Our Ref: Y/12/21/NMA

Non-material amendment following grant of Y/103/18/PL (W/4000394) for minor alterations to building layouts and elevations

10 acre Field Land north of Grevatts Lane Bilsham Bognor

DRAWING TITLE
Approved Plan Layout Comparison

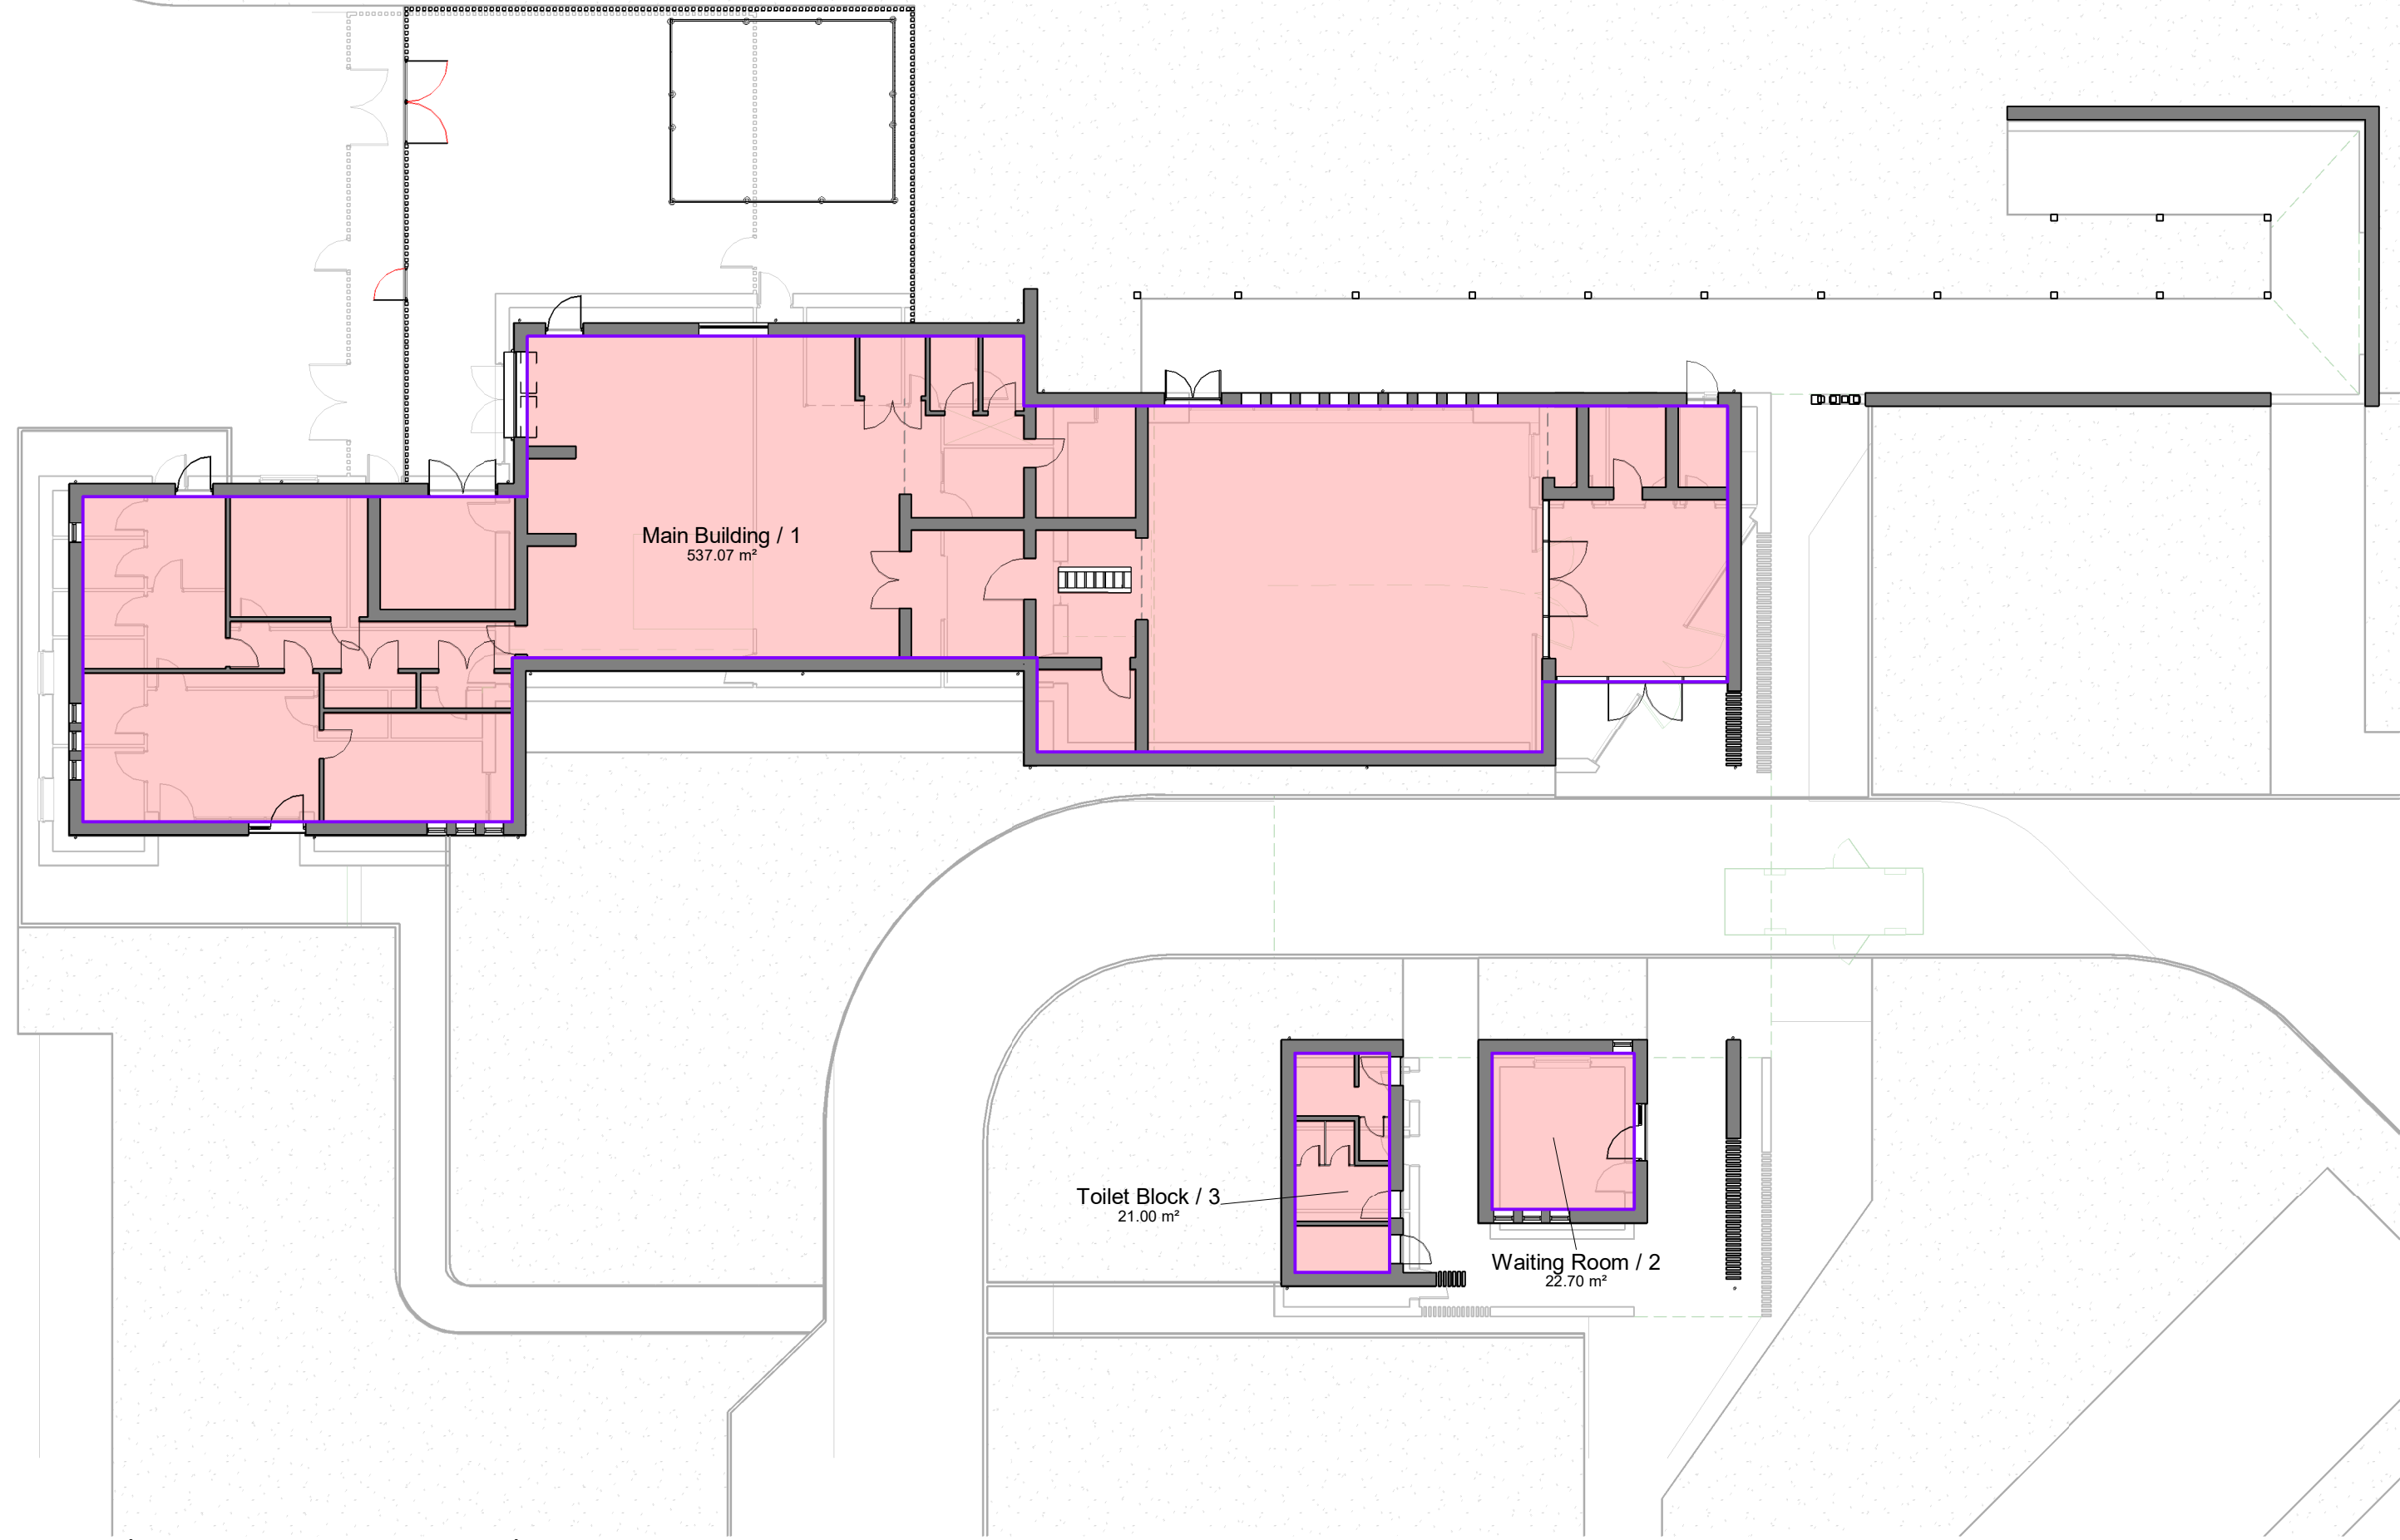
I refer to your recent application for a Non Material Minor Amendment. I note that you propose to make some minor alterations to the size, footprint and design of the approved building as shown on the accompanying drawings but with an overall reduction in its size (the floorspace reduces by 51.48sqm to 578.33sqm).

There are no changes to the overall height or bulk of the roofs and the footprint moves by less than 1m. I also note an enlargement of the rear external storage area and changes to the parking layout (with 2 less parking spaces than before) and changes to internal site roads/paths and landscaping.

It is considered that the proposed changes will not materially alter the appearance of the development approved by the planning permission, do not conflict with any conditions of the permission, do not breach any planning policy, do not warrant re-consultation and are within the maximum dimension change tolerances. Whilst the scheme does slightly reduce the amount of parking spaces, it is noted

that there are no adopted parking standards for crematoria and that the parking provisions remains in excess of that advised by the Federation of Burial and Cremation Authorities (FBCA) as referred to in the officer report for Y/103/18/PL. In addition, WSCC previously advised that the level of parking provision significantly exceeded the average trip generation of each service.

The changes can therefore be considered as an NMA under section 96A of the Town and Country Planning Act 1990.
